## **DDA Compliance Statement – Performance Solutions Stage 2 DA Submission – Concept Amended III**

**Project:** Sydney Football Stadium Redevelopment (SFSR) Stage 2  
**Location:** Moore Park, Sydney, NSW.

**Date:** 25 May 2019

DRAWING
GRADING & LEVELS PLANS
Ground Level - Quad C

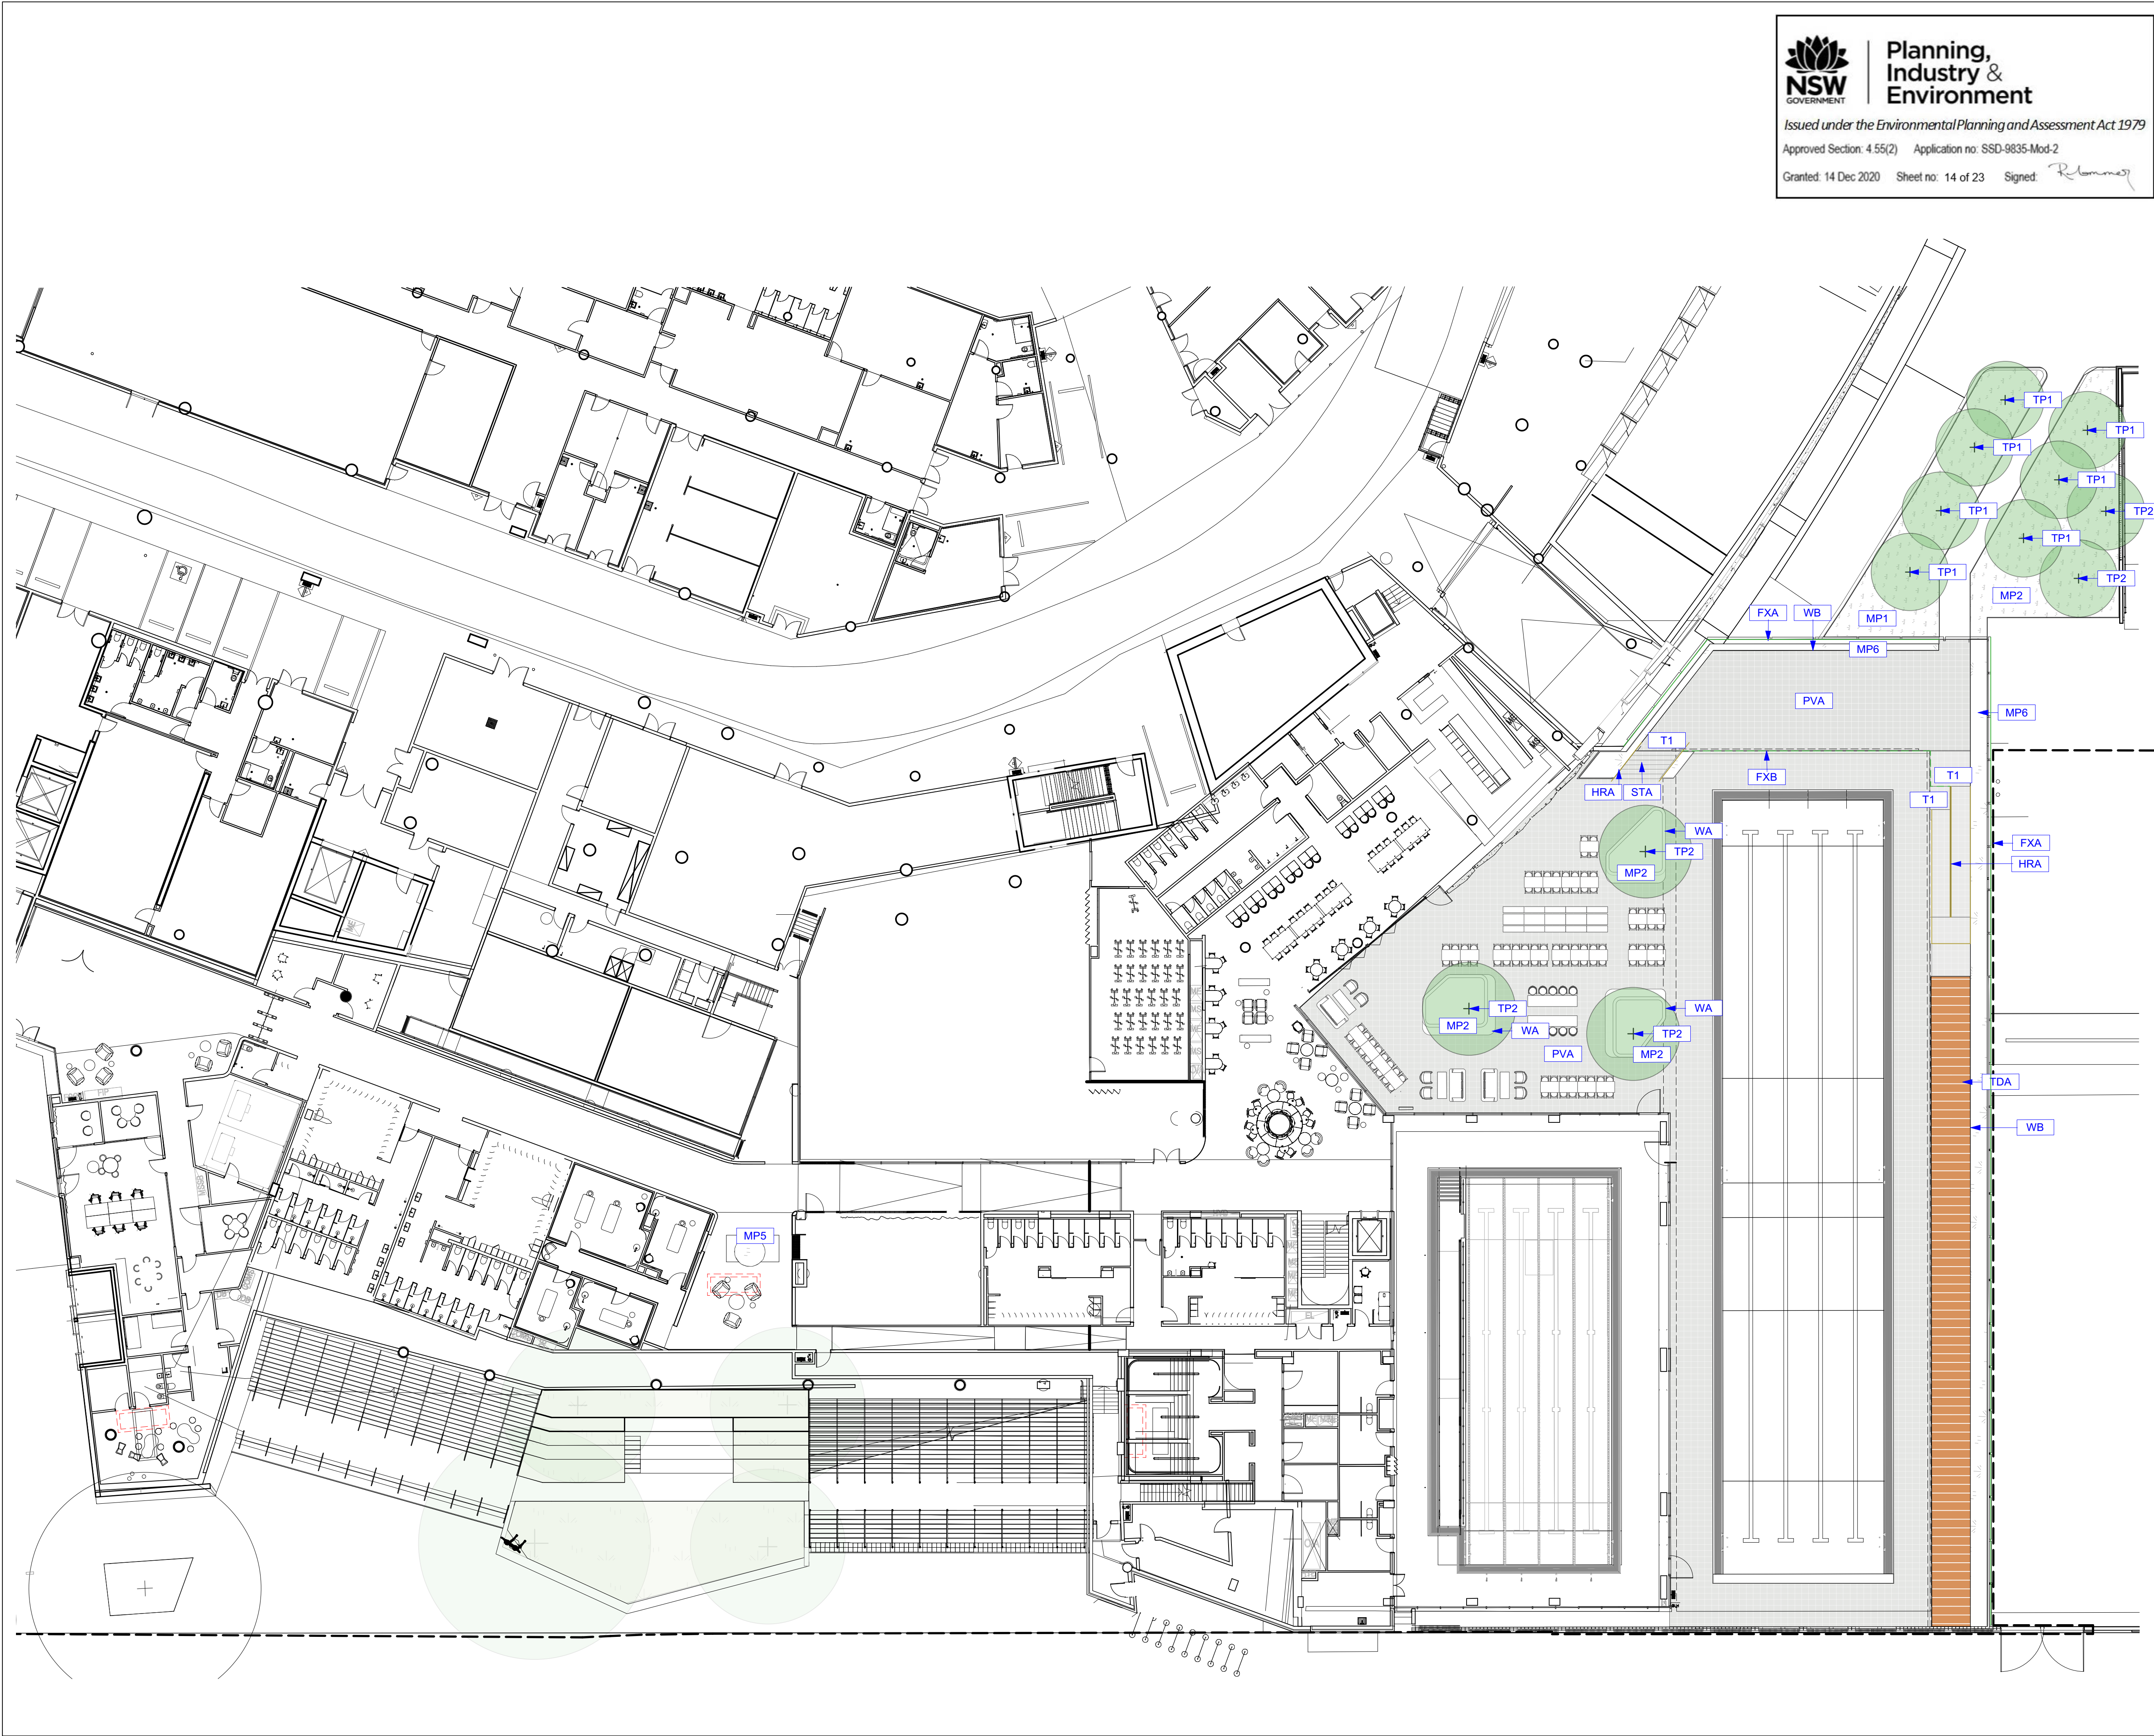
- Ground Quad C – 1:35 gradient occurring up to and through turnstiles is to be altered to be maximum 1:40 gradient for minimum 1450mm each side of turnstiles.

- Ground Quad C and D 1:14 grade ramps - have been adjusted to have less than 3.6m overall rise and later design phase documentation will show dimensions for ramps and landings in accordance with AS1428.1-2009 Clause 10 i.e. to provide landings (min 1200mm long) at maximum 9m intervals.

- Ground Quad D 1:20 grade walkways are to be confirmed to have minimum 1200mm long landings at max 15m intervals.
